Beavers Brook,
The Thatchway,
Angmering,
West Sussex BN16 4HJ

25 September 2018

Planning Application A/110/19/HH

Drawing: **PROPOSED**

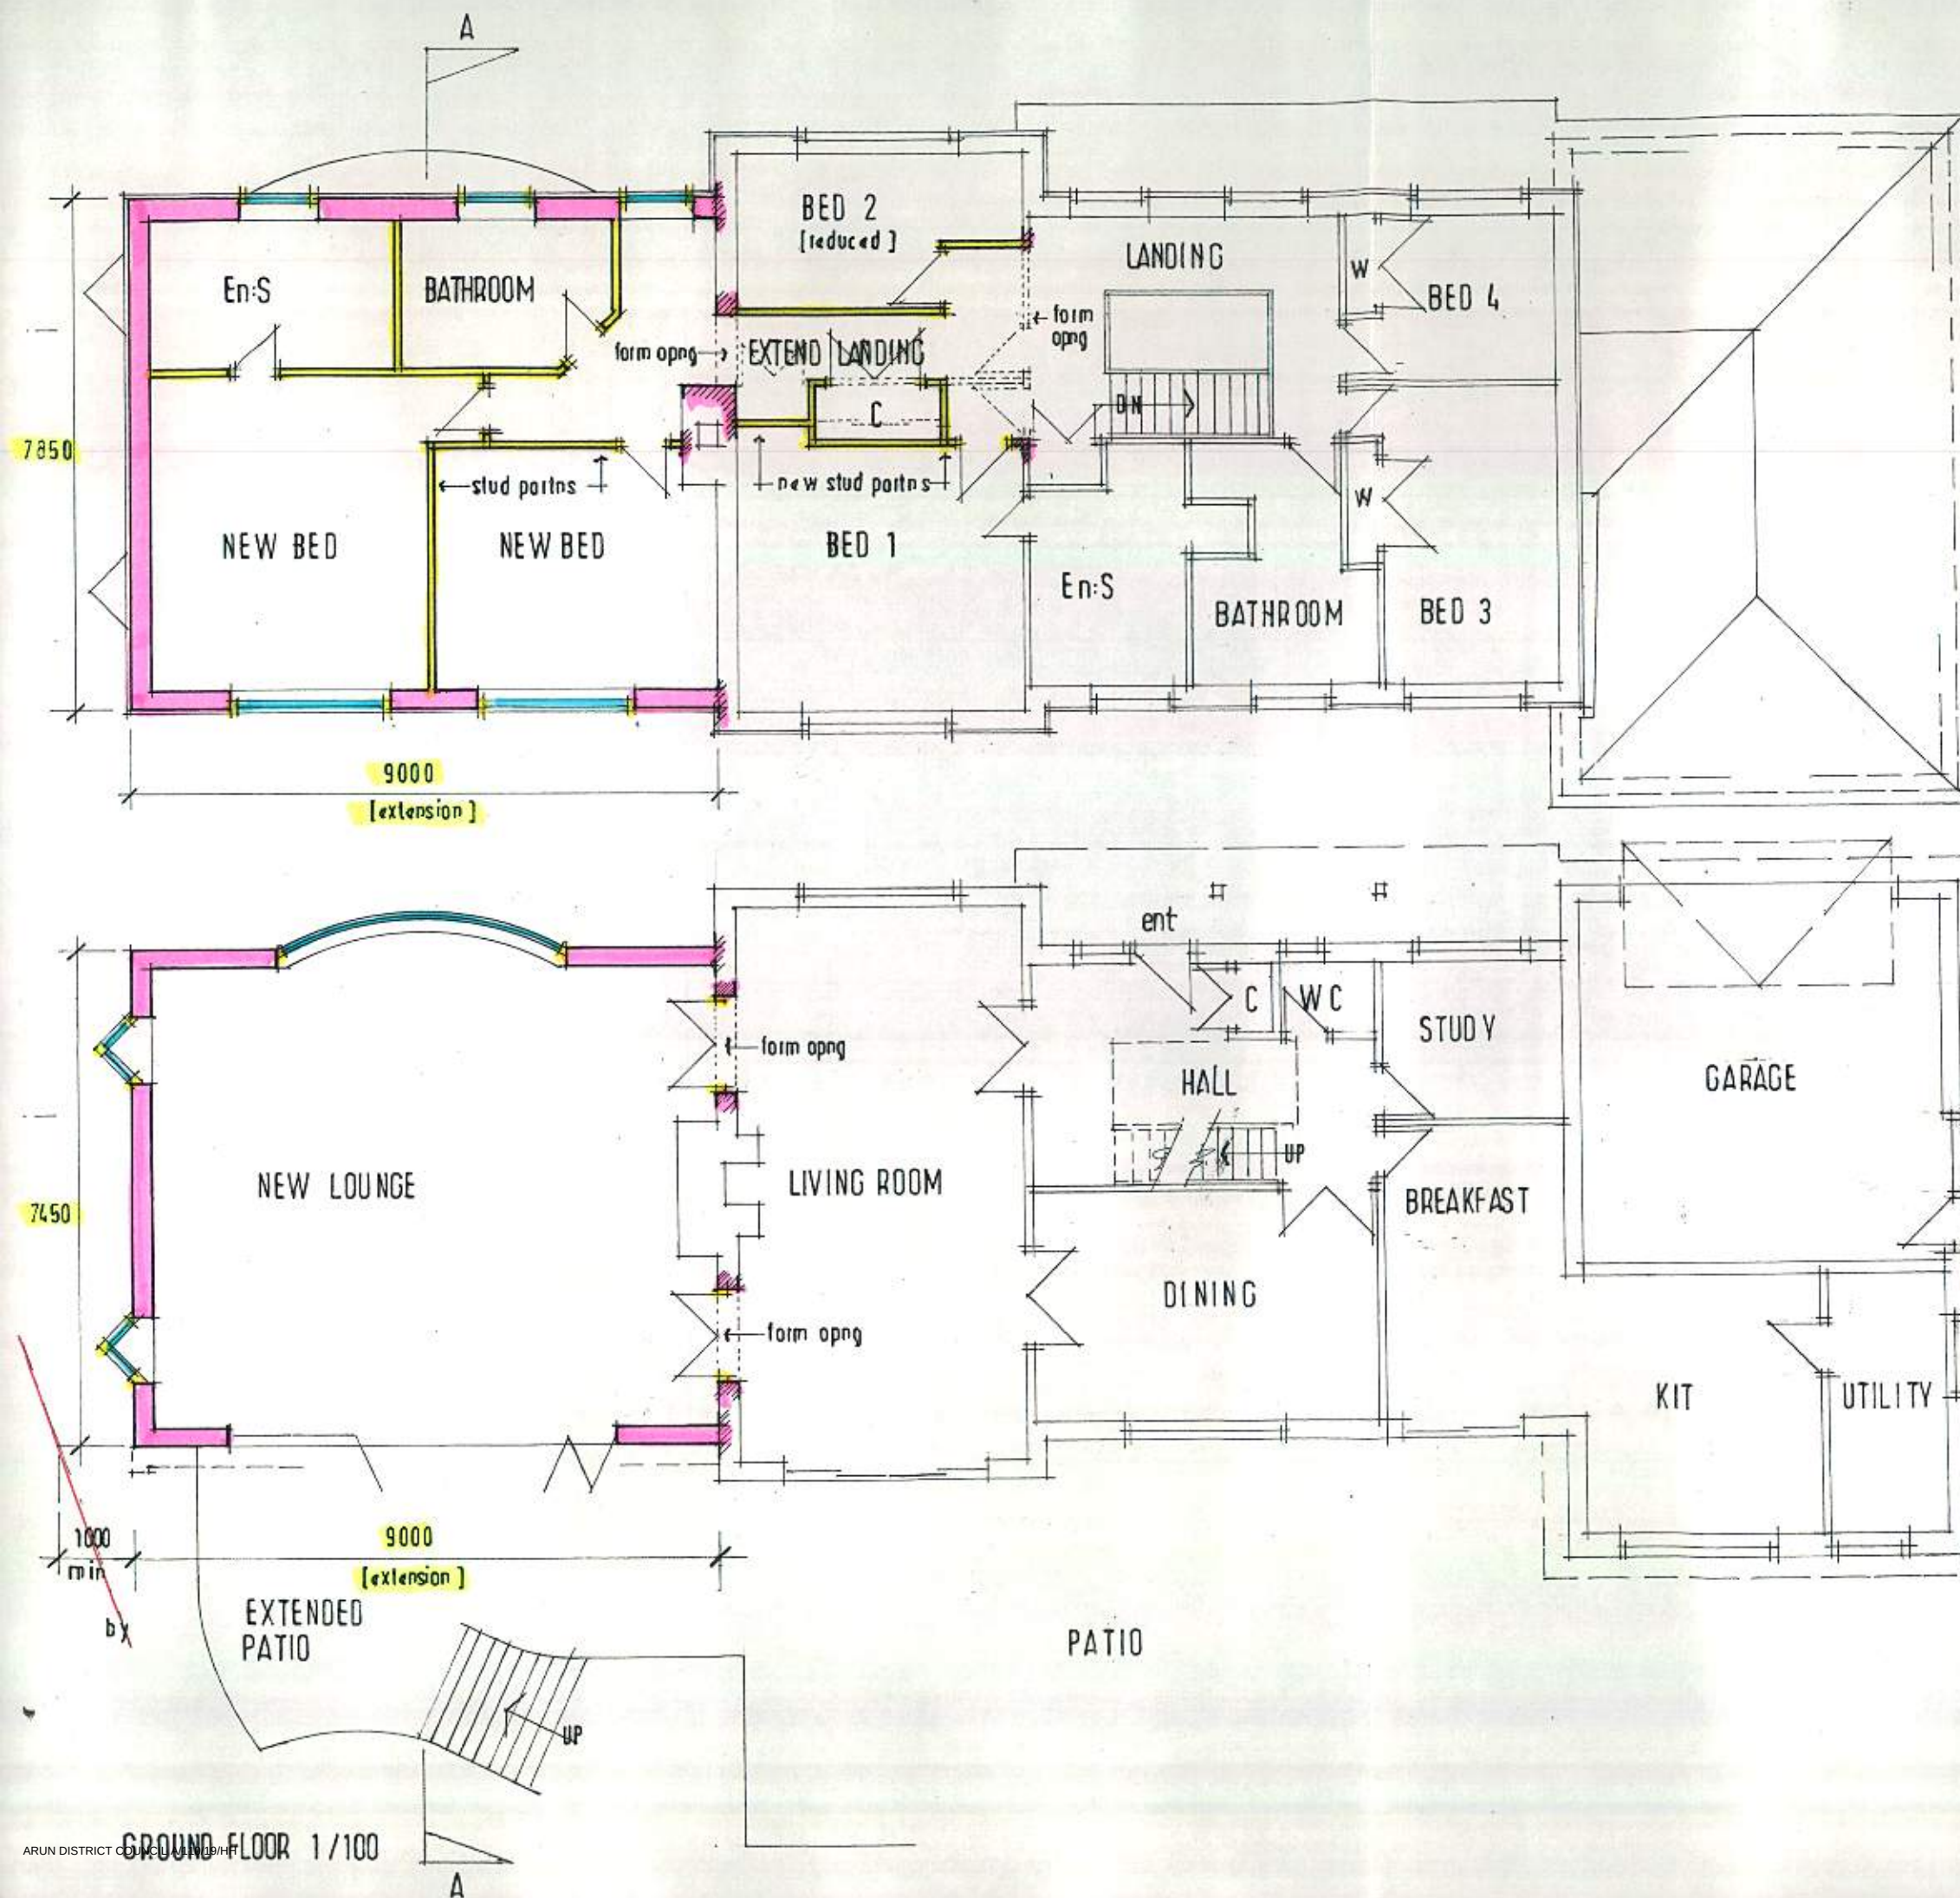
As the extension would come right up to our boundary and the base of the extended patio at the back would be at about the height of the top of our 1.8m fence anyone on it would look right down onto our garden from it. For this reason we object most strongly to any patio at all being built outside this extension.

The rear window on the western elevation would, we believe, look directly down into our garden and we therefore object to any window being put in on the western elevation which is above the height of our 1.8m fence.

It also means that we specifically object to the proposal for this extension to have ground floor side windows, as these would look over our fence, especially the rear (and closest) window.

Drawing: **LOCATION/BLOCK PLANS**

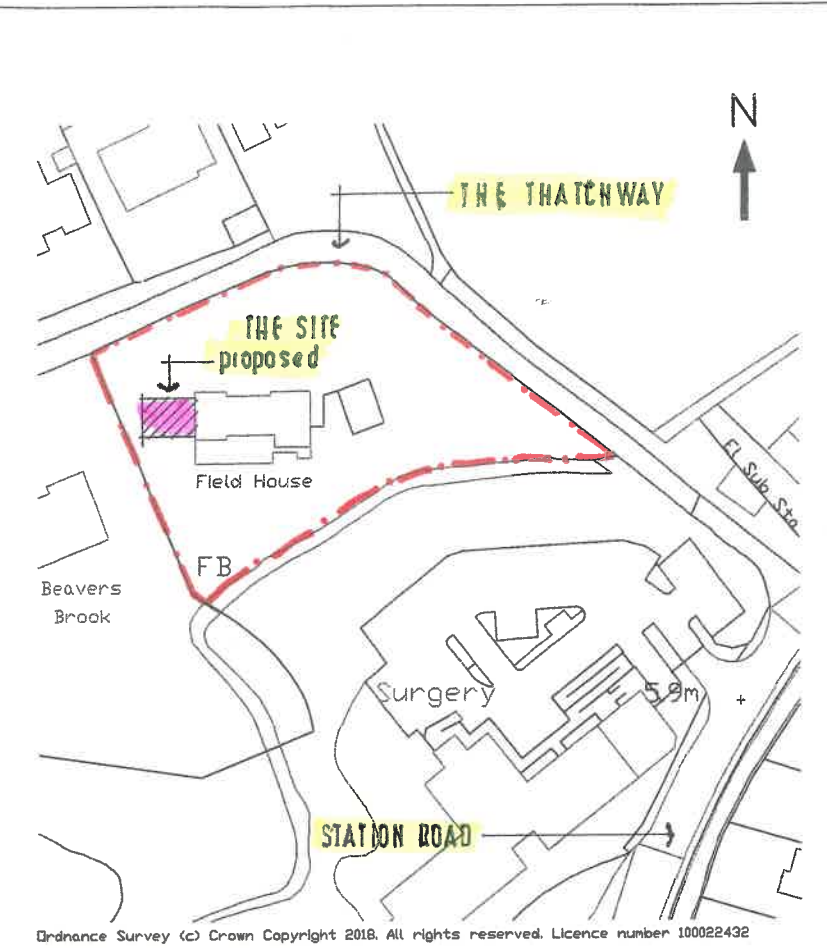
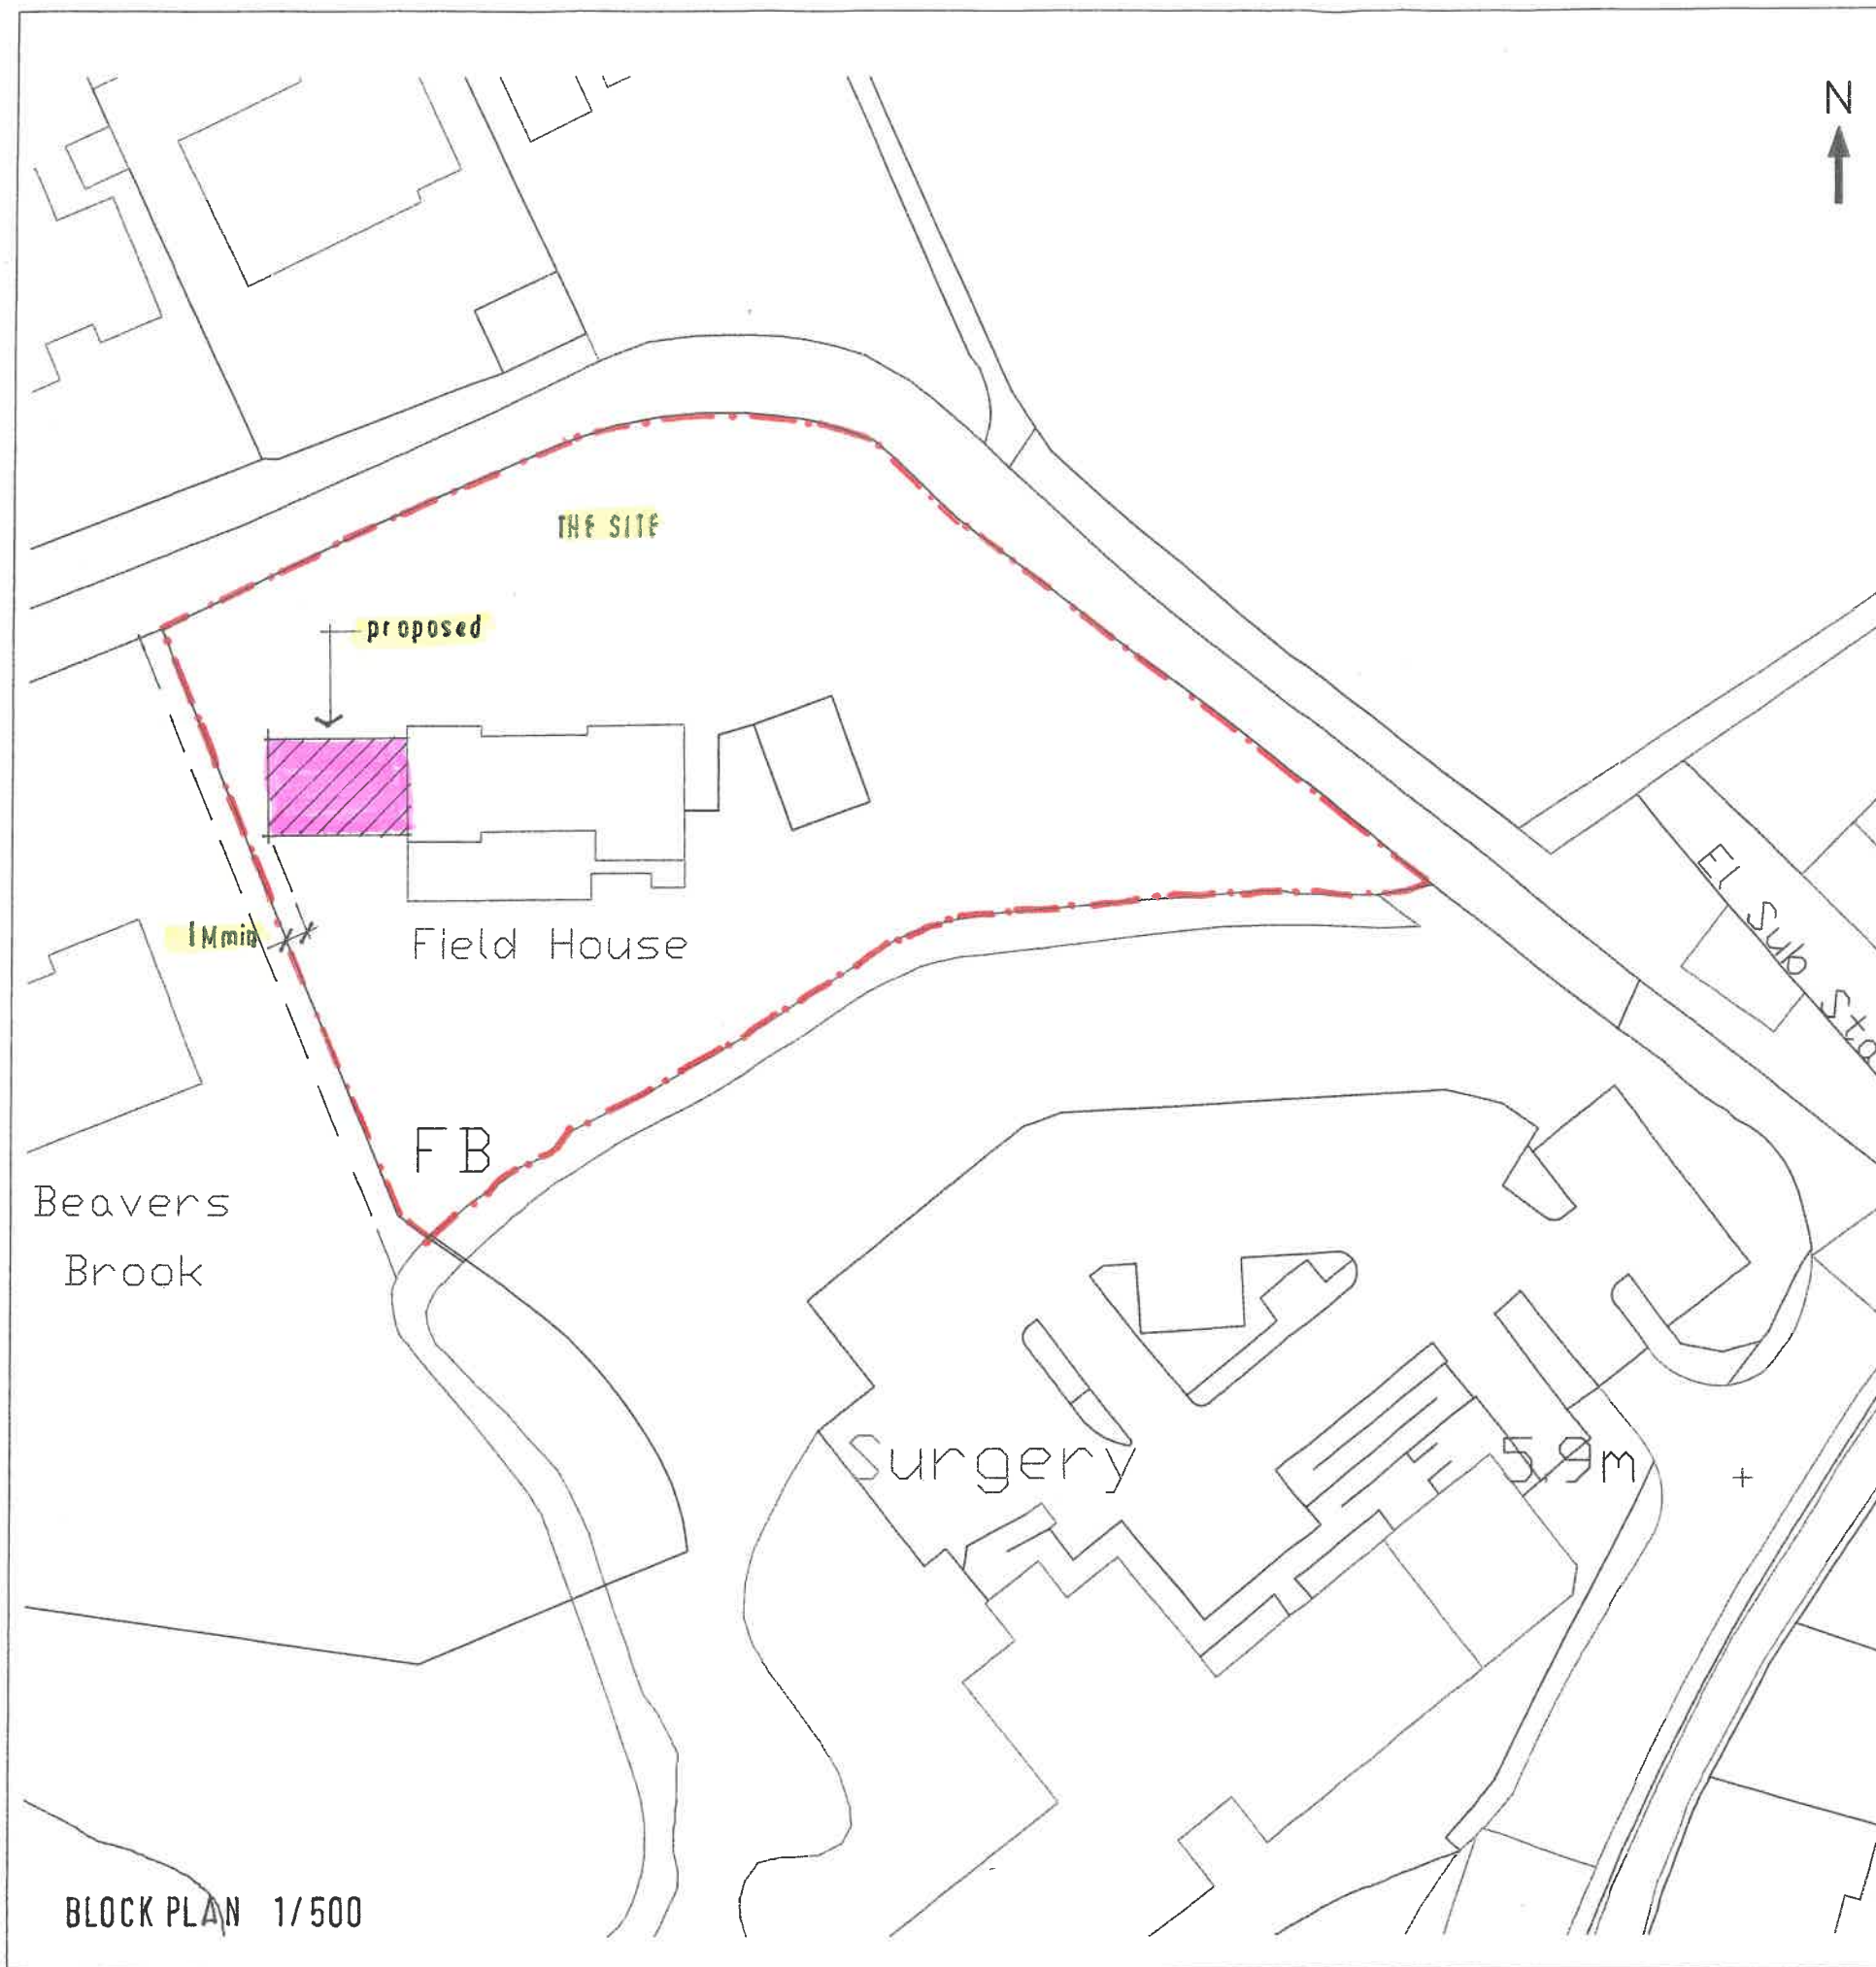
Indeed we are unsure exactly how far the extension actually would be from our boundary hedge (one metre is quoted but the plan fails to show exact distances from our boundary

or how the extension would inter-relate with our property). As such material facts are not addressed by this planning submission and for that reason it should be rejected.

Figure 1 below shows the planned extension with the planned patio (which is omitted from the overhead plan submitted to you) included. I know the patio is a slightly different shape on the southern side to the rectangular depicted in figure 1 but it obviously comes very close to, or perhaps even over, the boundary of Beavers Brook. It appears that the patio will be 4.5m wide and that most of the western end of this patio will be within a metre of our boundary, shading out our hedge.
